**Laurie Leader - Re: BP#2015-00154 35 Knickerbocker Lane (Peaks Island) - Plan review comments**

From: Laurie Leader <[LRL@portlandmaine.gov](mailto:LRL@portlandmaine.gov)>  
To: pleong1 <[pleong1@aol.com](mailto:pleong1@aol.com)>  
Sent: Thu, Mar 12, 2015 1:12 pm  
Subject: BP#2015-00154 35 Knickerbocker Lane (Peaks Island) - Plan review comments

Section / Deck detail	
Peter Pleong Nicklebocker Rd. PEAKS ISLAND, MAINE	
Scale:	1/4" = 1'-0"
Date:	10/12/2013
Drawn by:	ML
Sheet No.:	D2

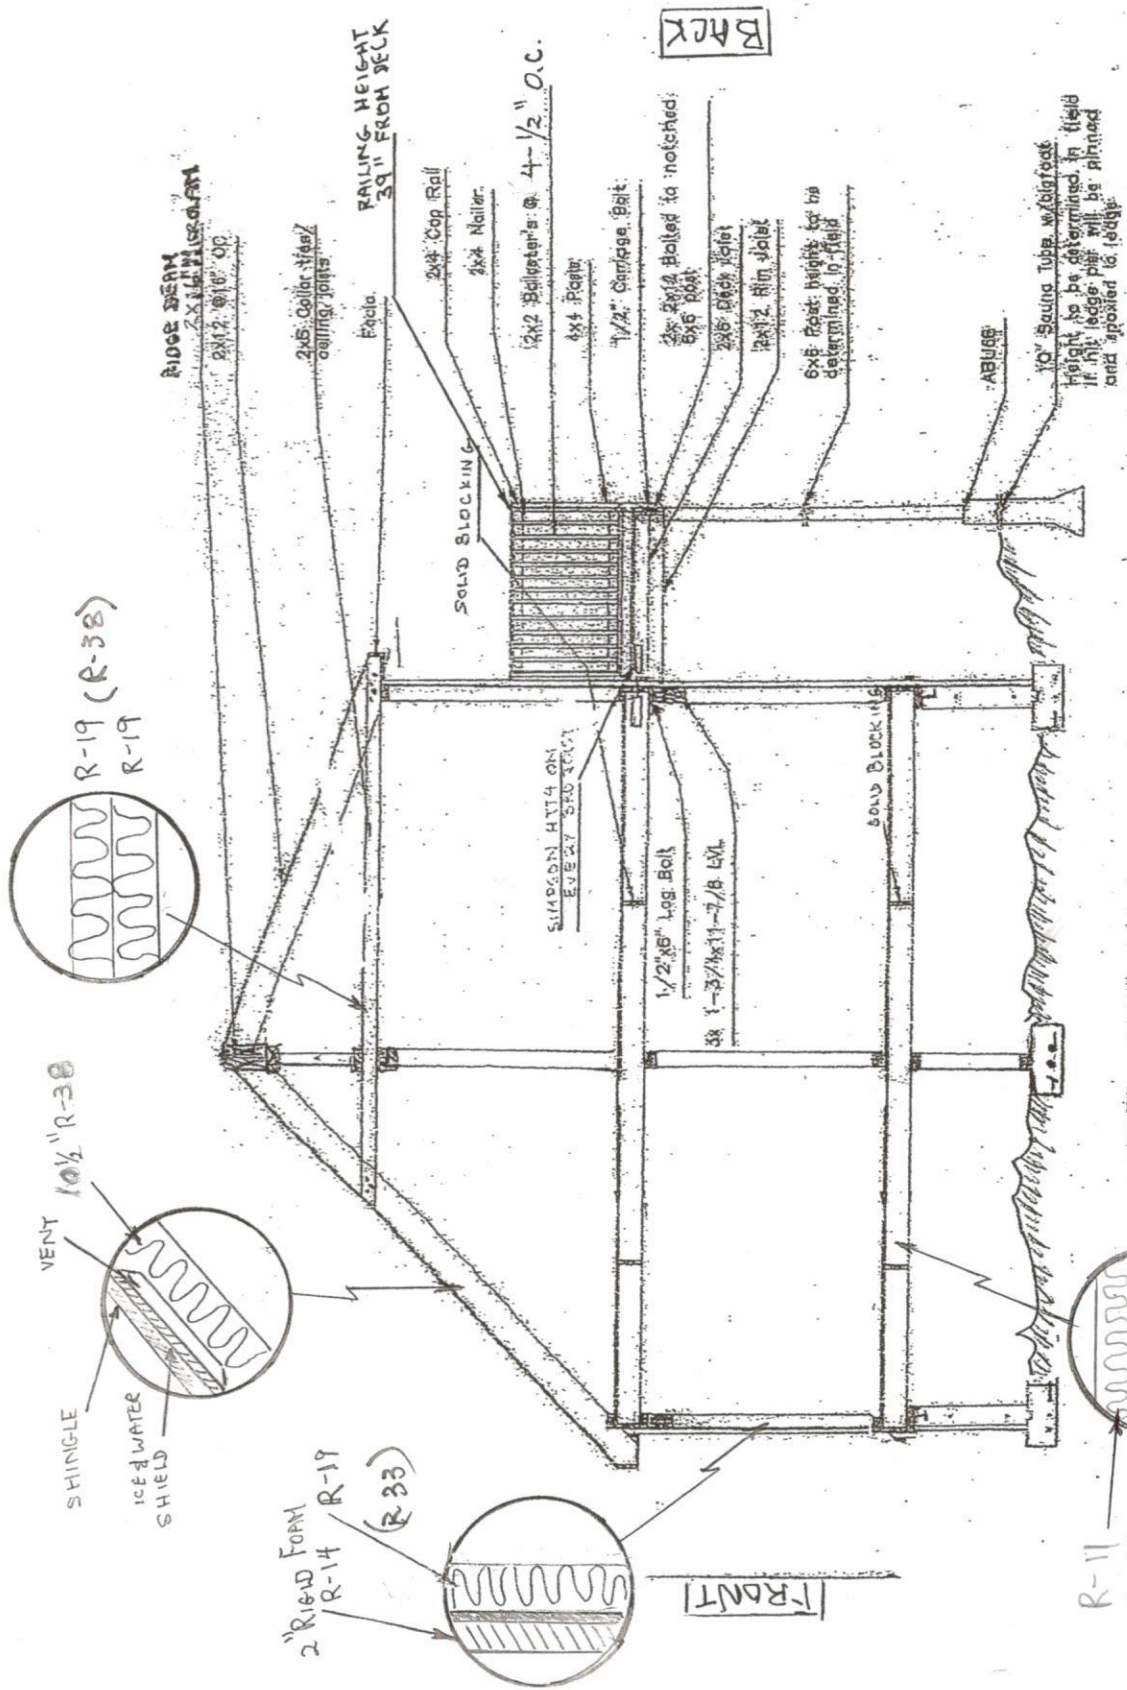
I have reviewed the drawings submitted. The only revision needed is the R value of the floor needs to be revised per Table 402.1.1 of the 2009 IECC for climate zone 6. An R30 is required for the area between the floor and crawl space. Other than that, I will need the ResCheck as we discussed. I emailed Craig Messenger in our fire department and he just signed off on your permit. Once I sign off, the permit will be issued within 1-2 business days.

Laurie: Attached please find the file detailing the revision to the insulation for the area between the floor and crawl space. It will consist of R-30 batting and 1" continuous foam totaling R -37. Attached lease also find 2009 IECC REScheck compliance certificate. Please let me know if you have any further questions. Peter
